City of Albuquerque

December 12, 1985

REF: ENGINEER'S CERTIFICATION FOR WATER WORKS SALES (J10-D11) ENGINEER'S
STAMP DATED 11/29/85

RE: ENGINEERING CERTIFICATION FOR DRAINAGE PLAN,
WATERWORKS SALES (J10-D11)

WATERWORKS SALES
ENGINEER'S CERTIFICATION
NOVEMBER 1985

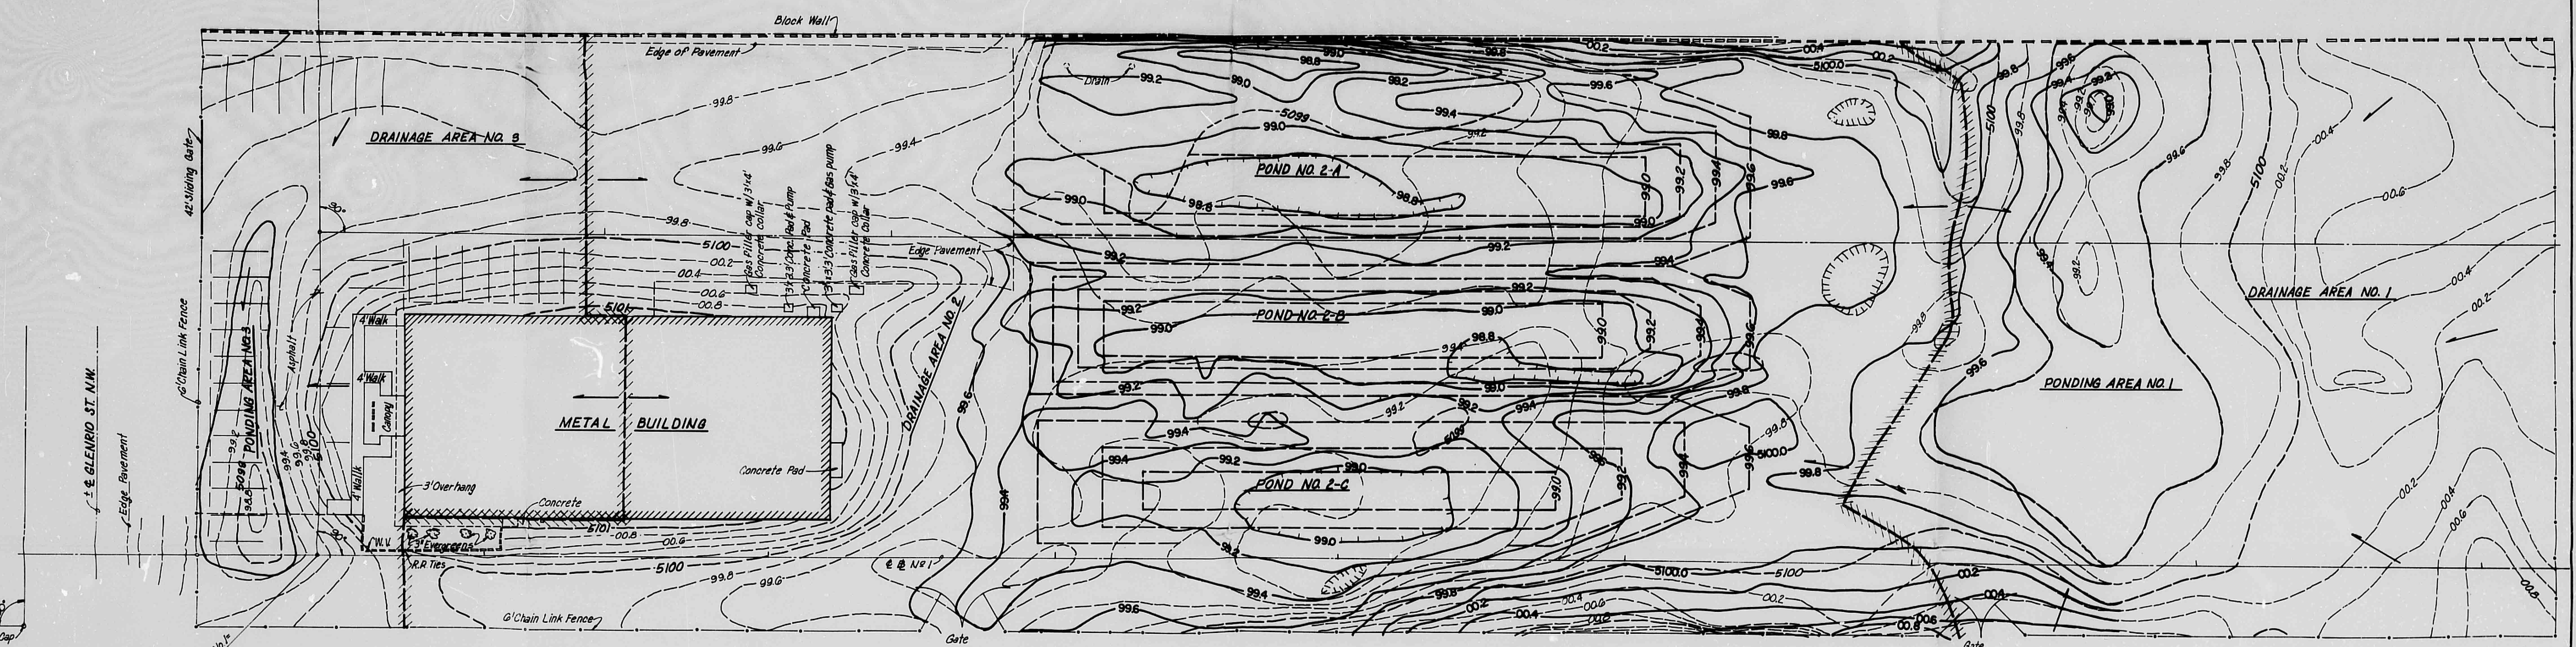
1. Information sheet designating resubmittal.
2. Engineer's stamp with signature and date.
3. Calculations showing developed flow rates along with the proposed ponding volume.
4. Detail showing the proposed ponding area along with the required elevations for construction purposes.
5. In placing the pipes back into the proposed ponding area, how much displacement of volume do you anticipate? Please address.
